Application No: FG/57/22/PL
Site Address: 12 Little Paddocks Ferring BN12 5NJ
Description of works: Demolition and erection of 1 No new dwelling. This application is in CIL Zone 4 and is CIL Liable as new dwelling.

Thank you for your internet representation made on 12th May 2022 which has been recorded as an objection with the comments as follows:

DRAWING No.
**Drawing 1
Existing & Proposed
Floor Plans & Elevations**

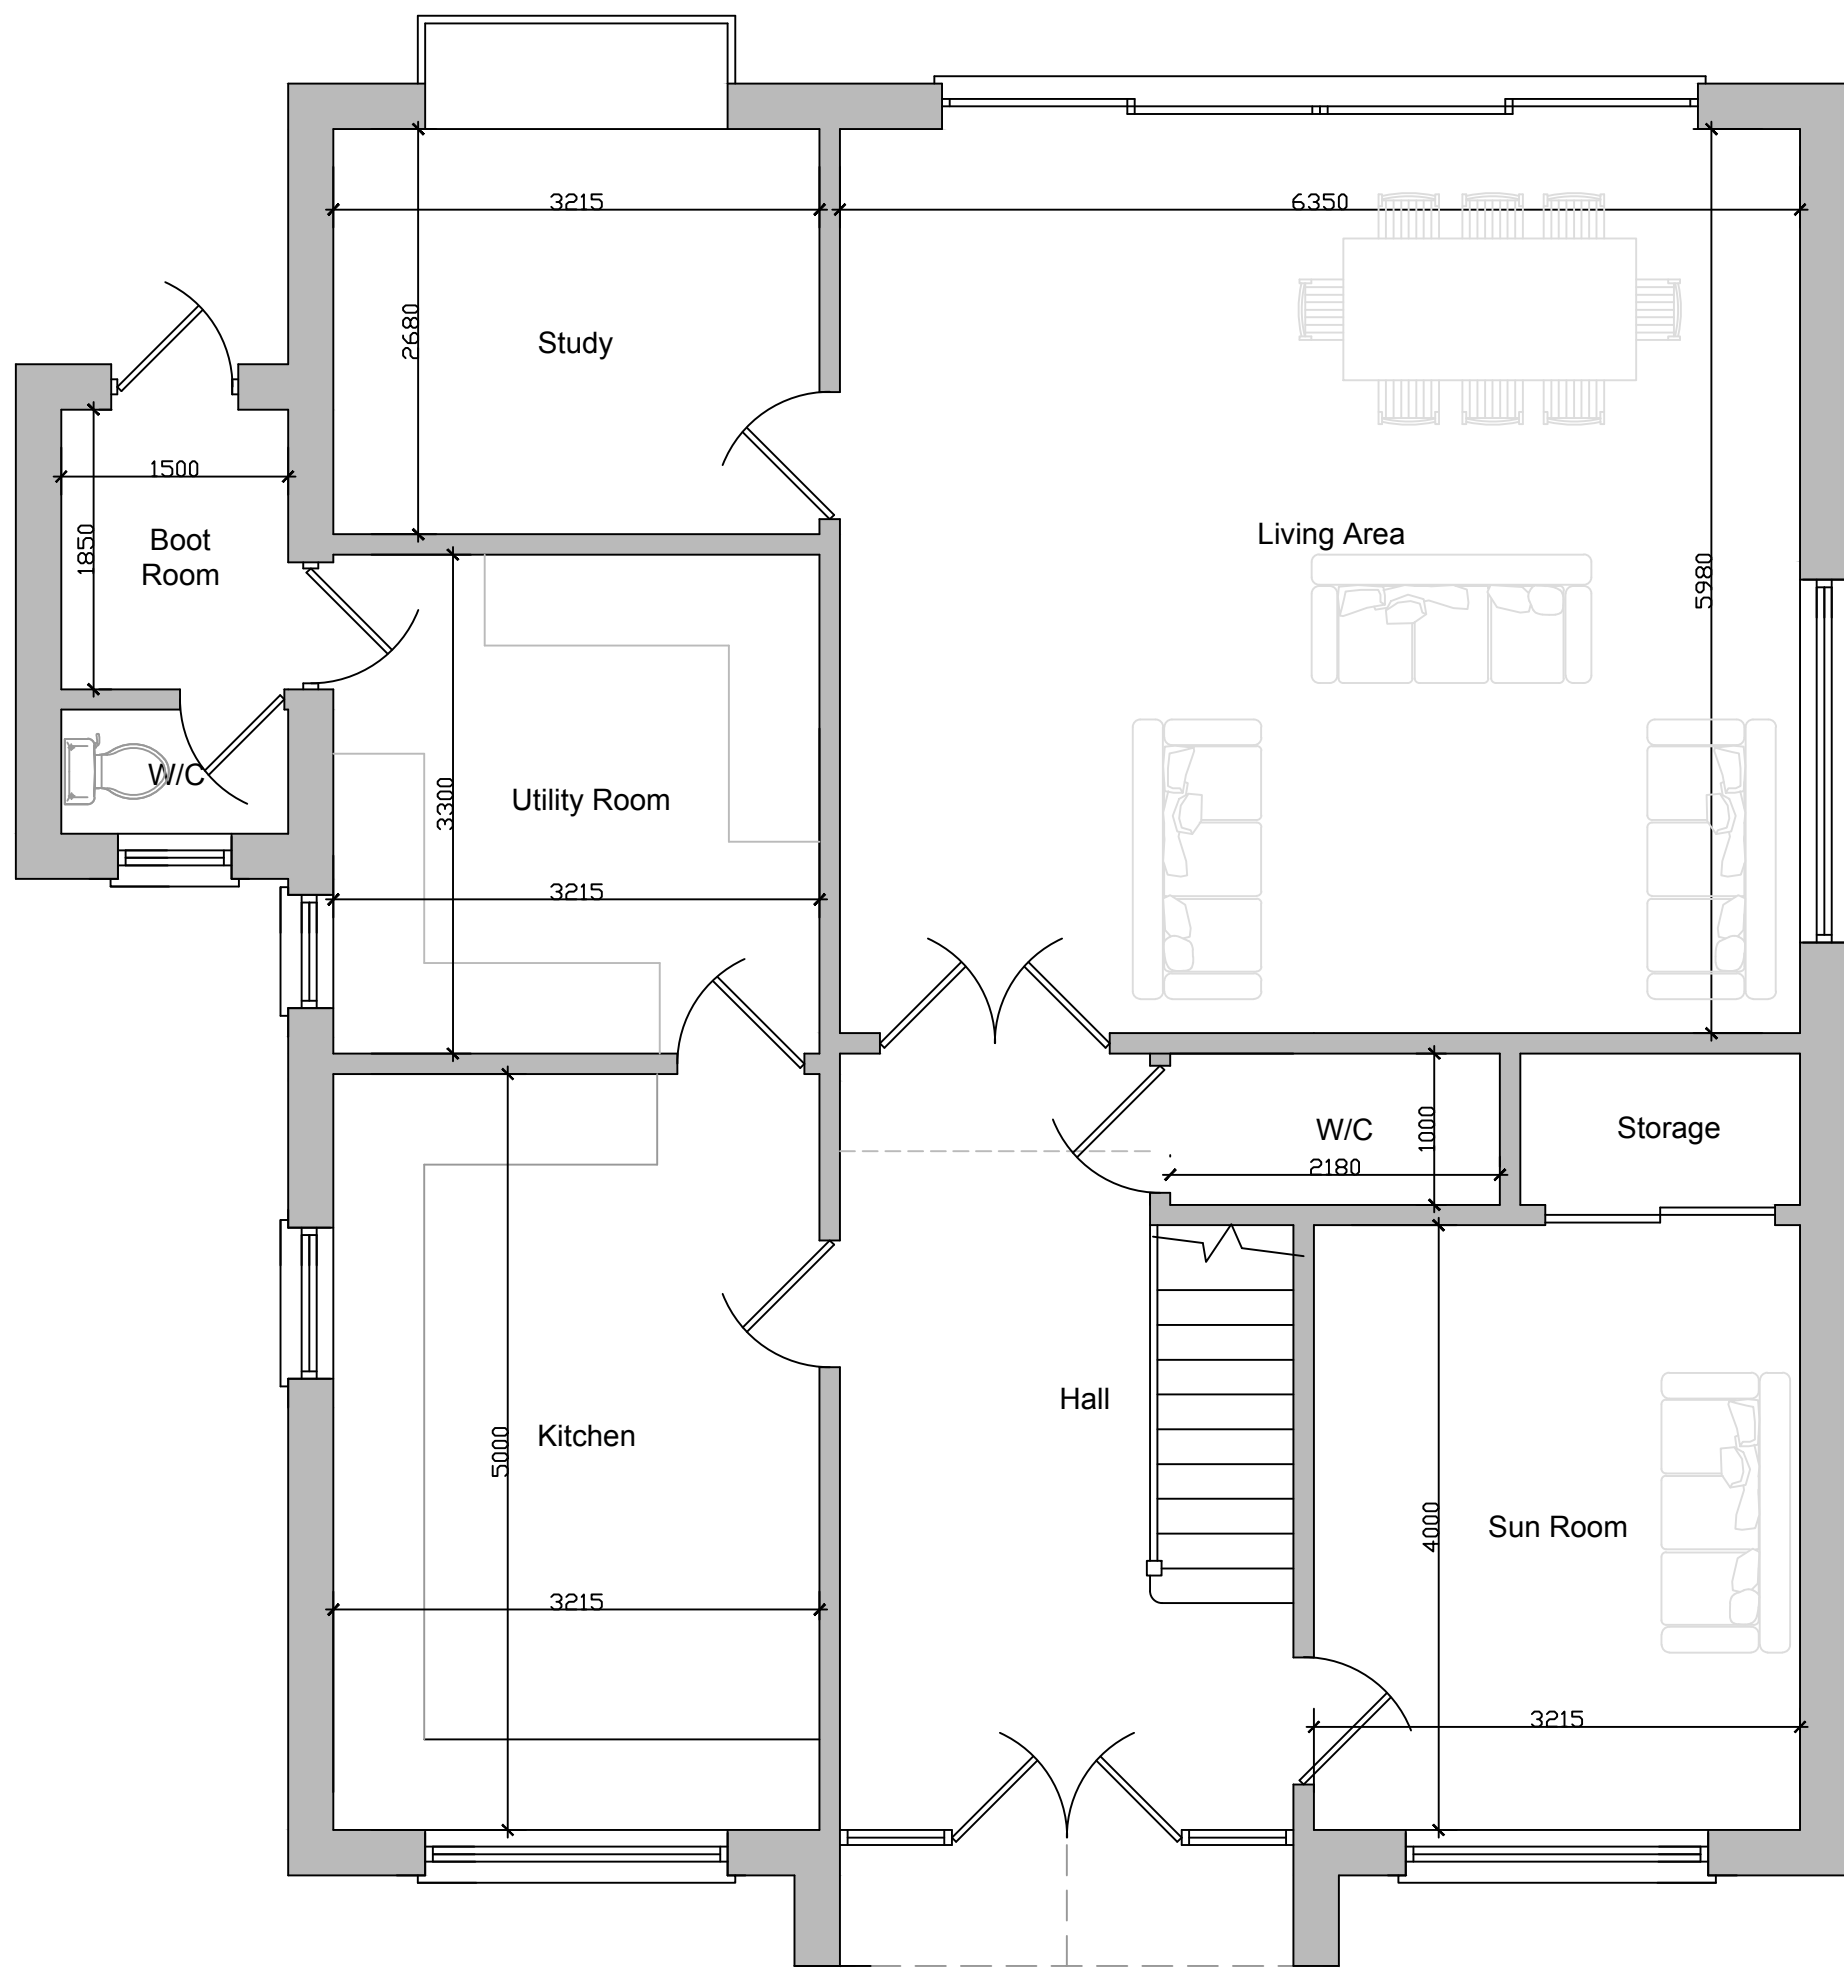
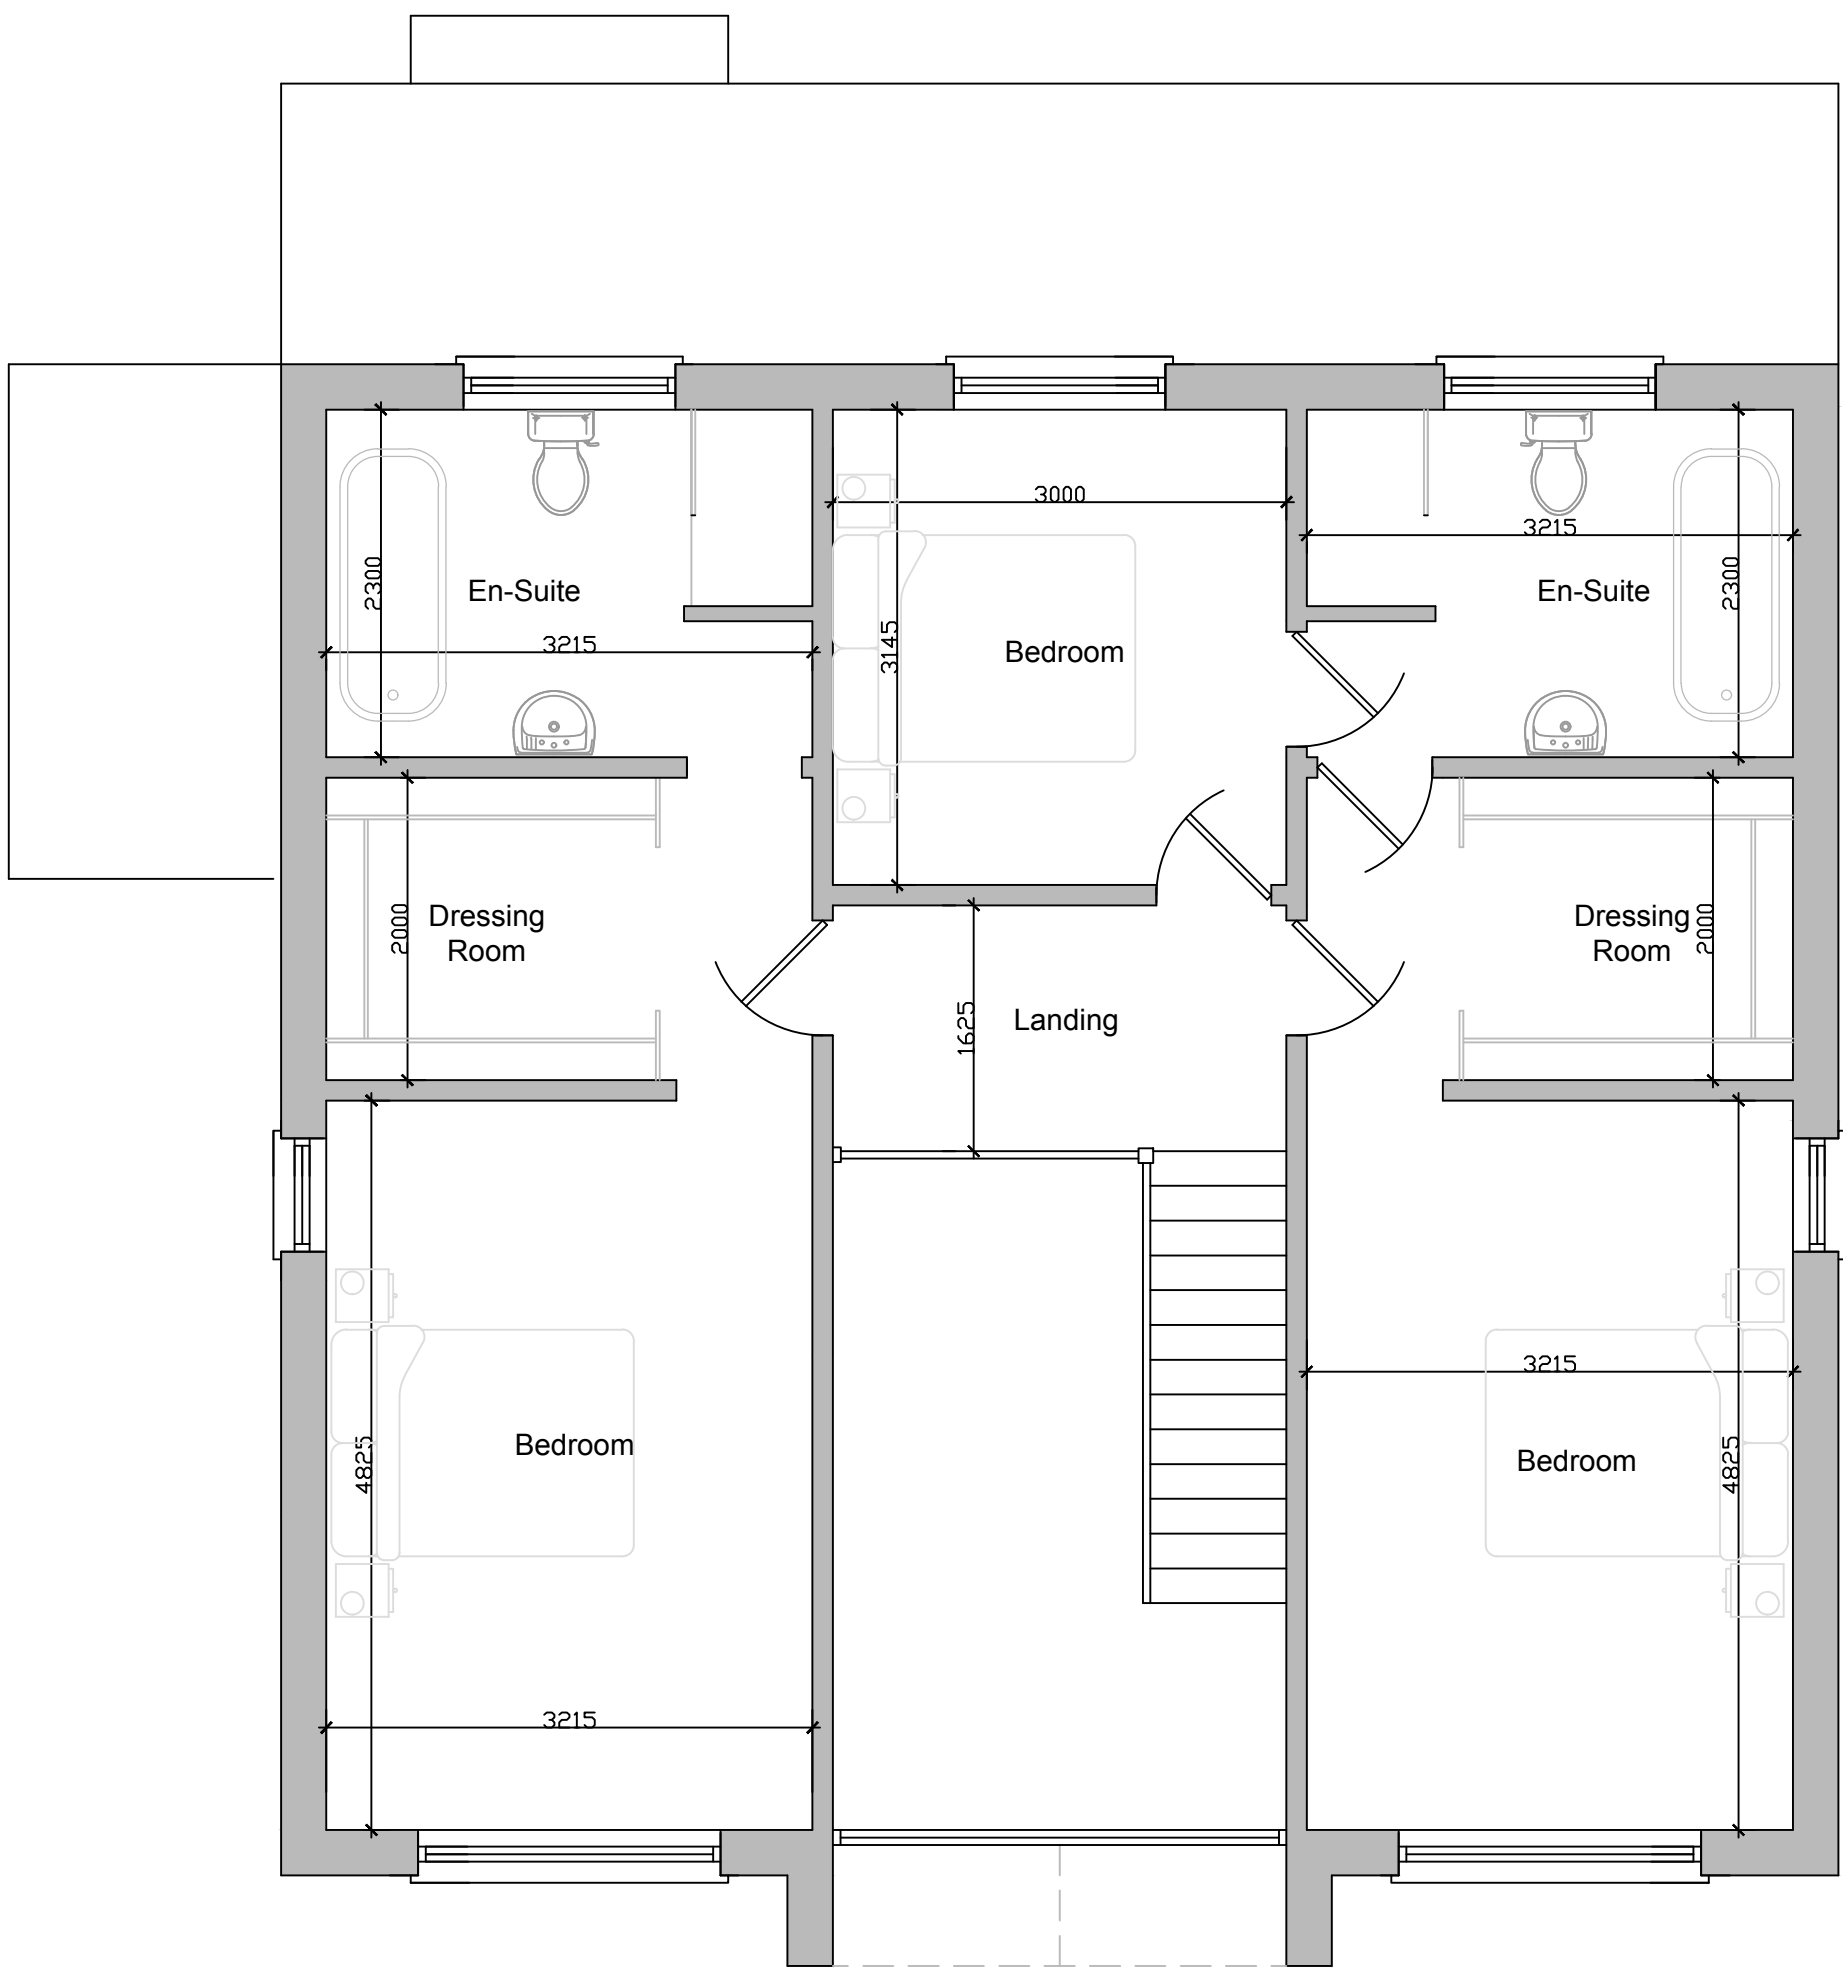
This development is out of character with the Little Paddocks, it is far too big being 2 storey. Most buildings in the Paddocks are bungalows. If you give permission for this development all dwellings in the Paddocks are given the green light to become 2 storey buildings and more developers will pounce on the Paddocks. We do deserve some peace and quiet and not to have continuous development. Do we really need more luxury houses in Ferring? Bigger houses are less affordable. Bungalows are a feature of the Ferring environment. Thanks.
